Date: 09-Jul-2026
Our Ref: 2026/90198

PRIOR APPROVAL FOR ALTERATIONS TO BRIDGE MVL3/54, KETTLE LANE, NORTH-EAST OF MARSDEN
KETTLE LANE, MARSDEN, HUDDERSFIELD, HD7 5XB
APPLICATION NO: 2026/90198

Drawing Number: 167037-TGP-54-MVL3-DRG-T-LP-165401 Revision: P02

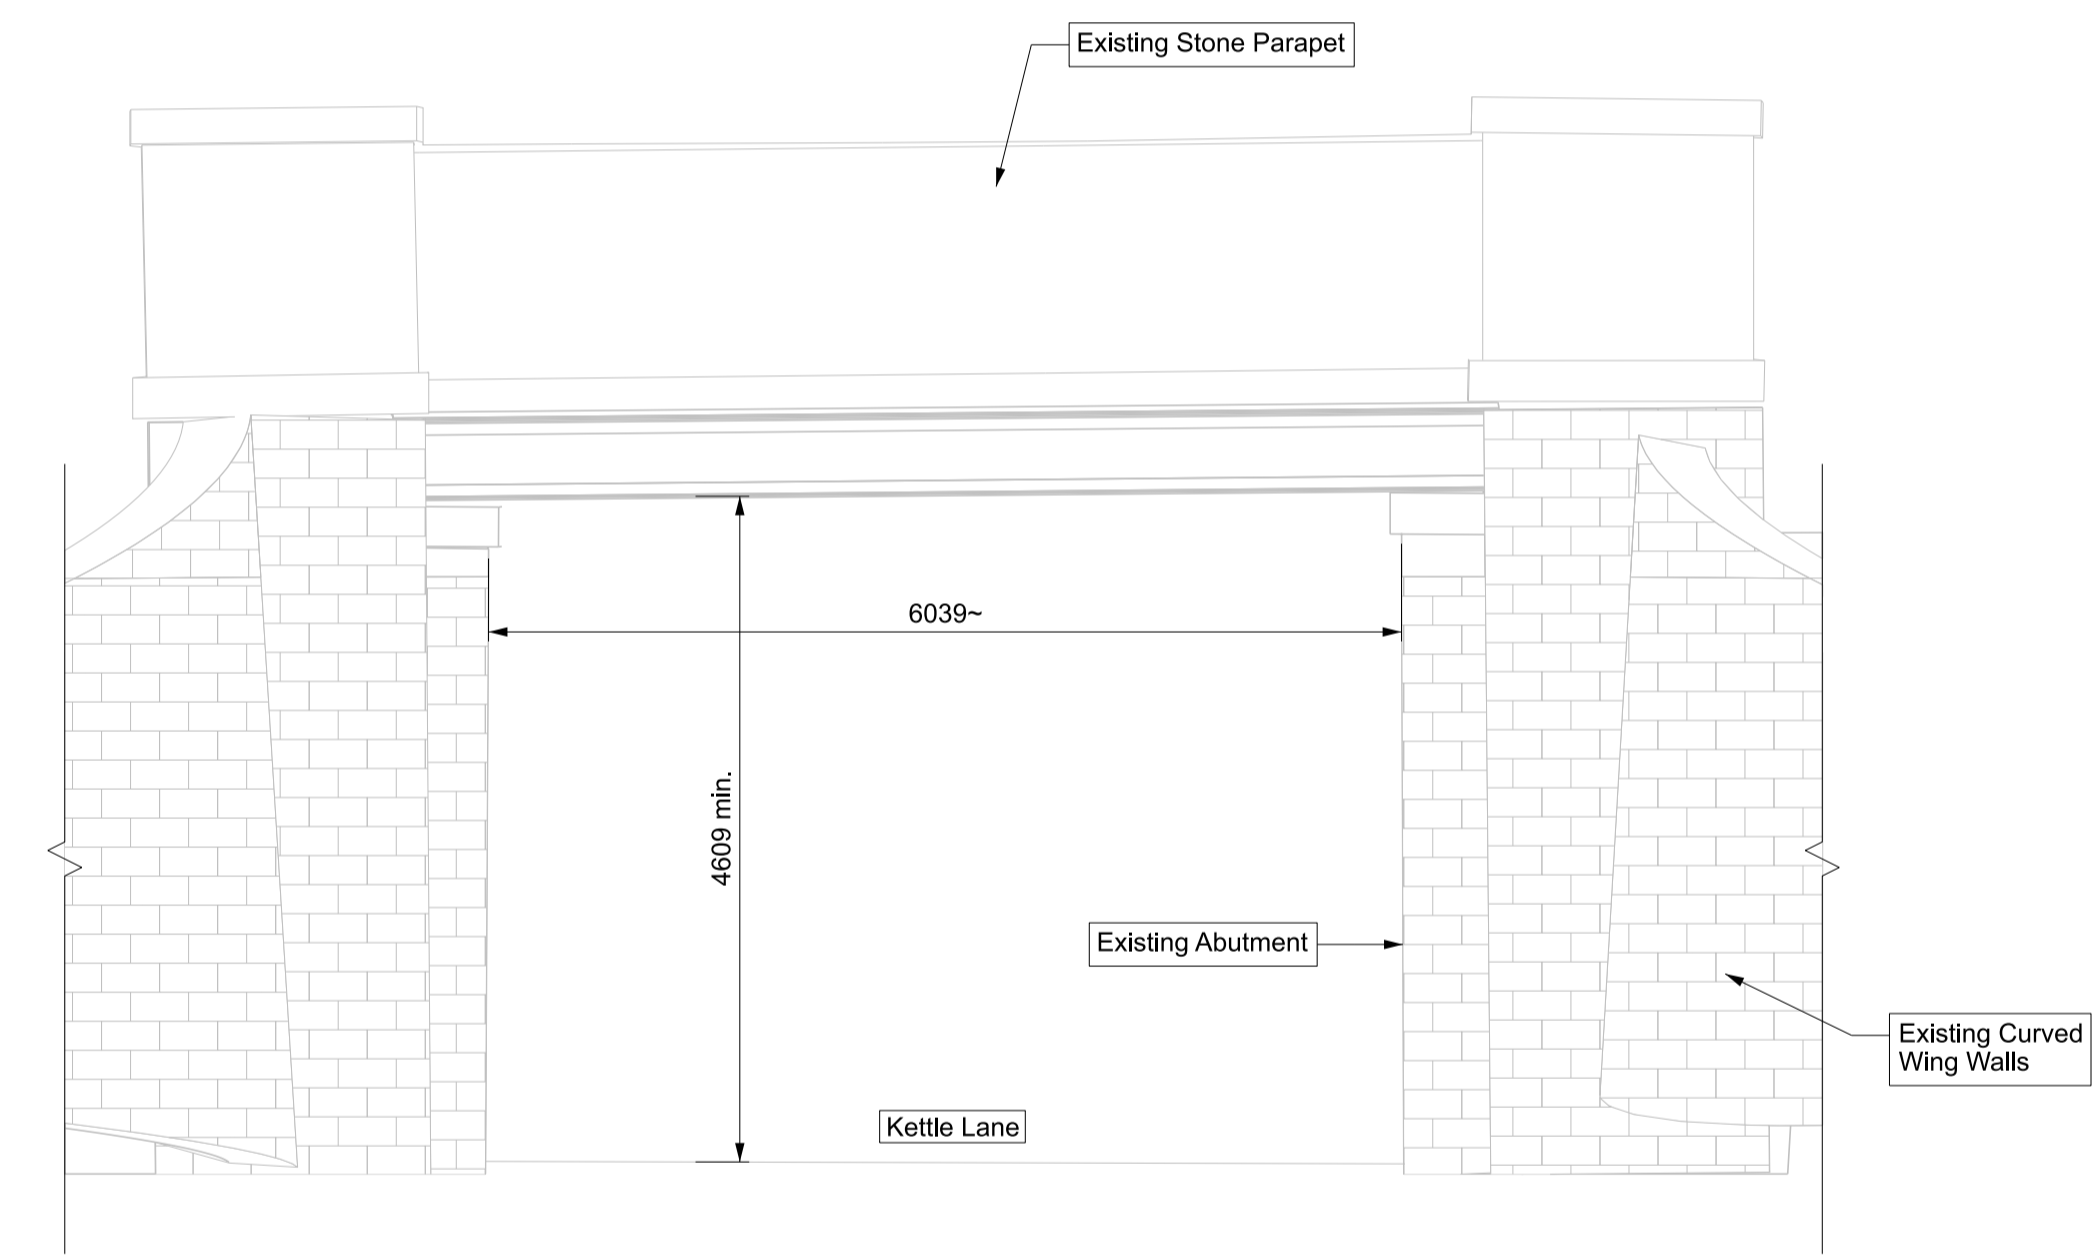
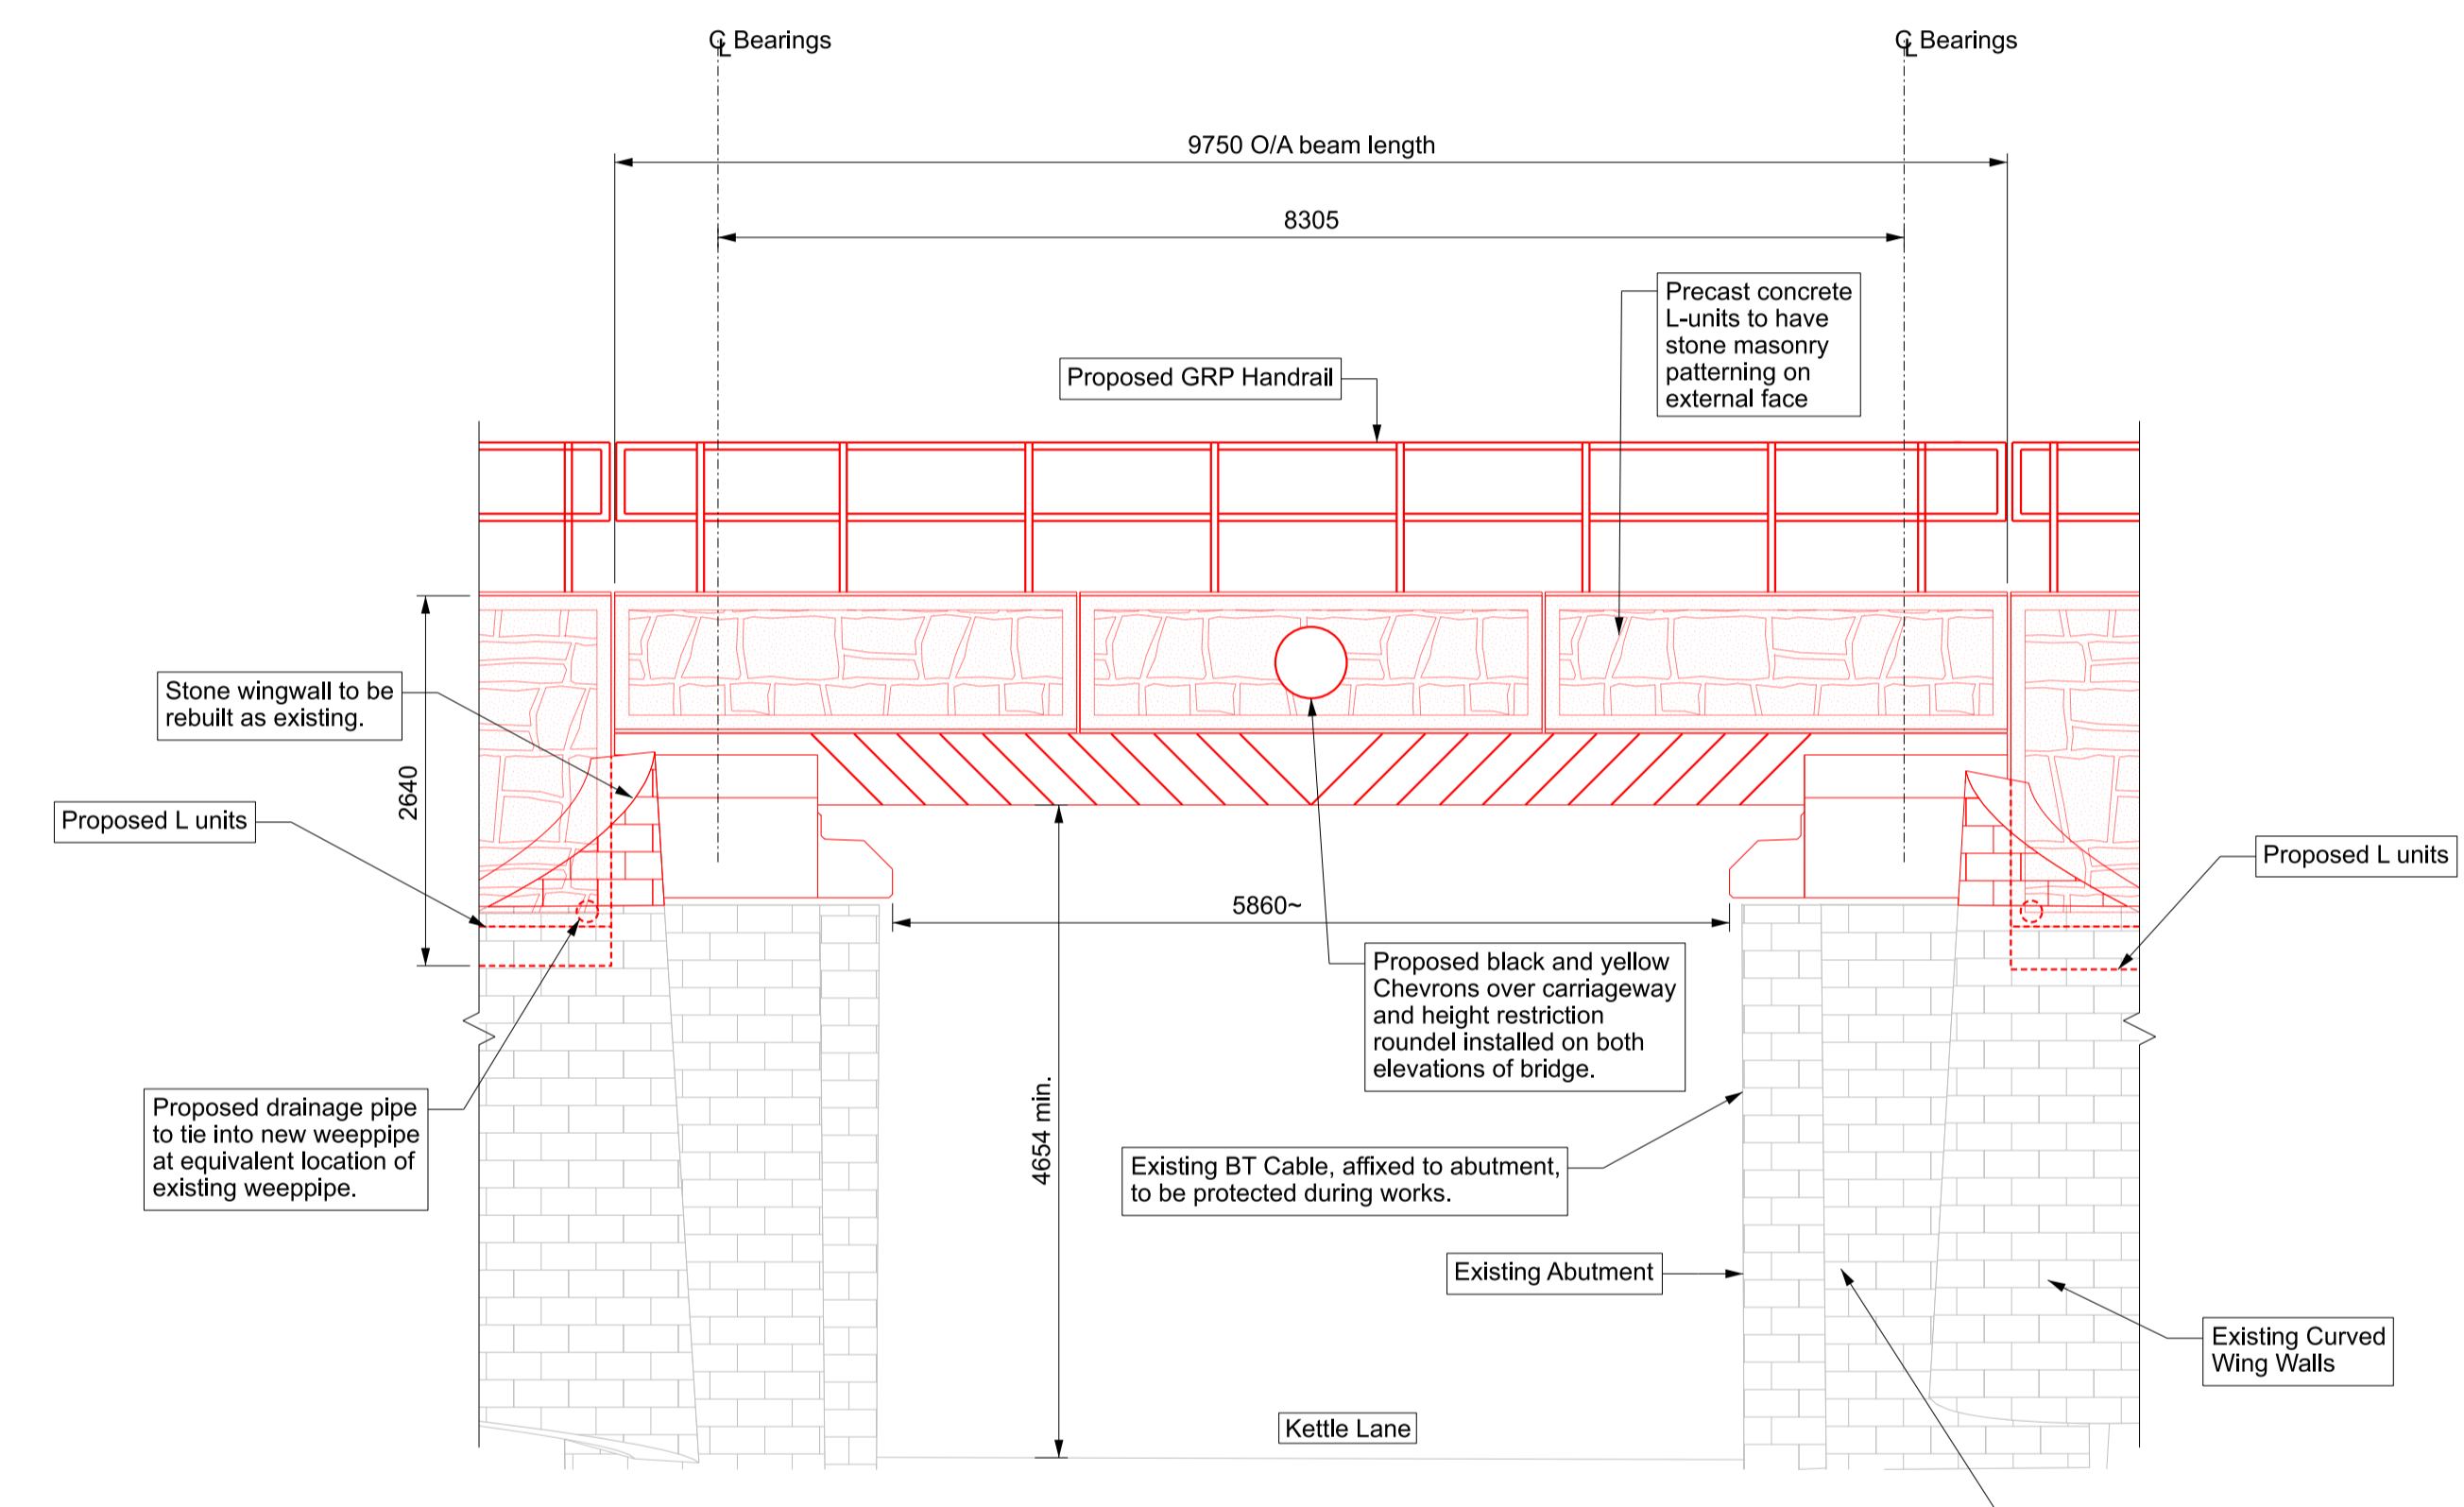
1. Notwithstanding the submitted plans, a sample of the parapet finish[es] shall be submitted to and approved by the Local Planning Authority, prior to their installation. The external treatment of the parapet finish[es] shall reflect the retained stonework of the bridge in terms of colour, texture, finish and coursing.
Reason: In the interests of visual amenity and the conservation of the Historic Environment and to accord with Policies LP24 and LP35 of the Kirklees Local Plan.
1. The GRP handrail shall be finished in a black or green powder coating
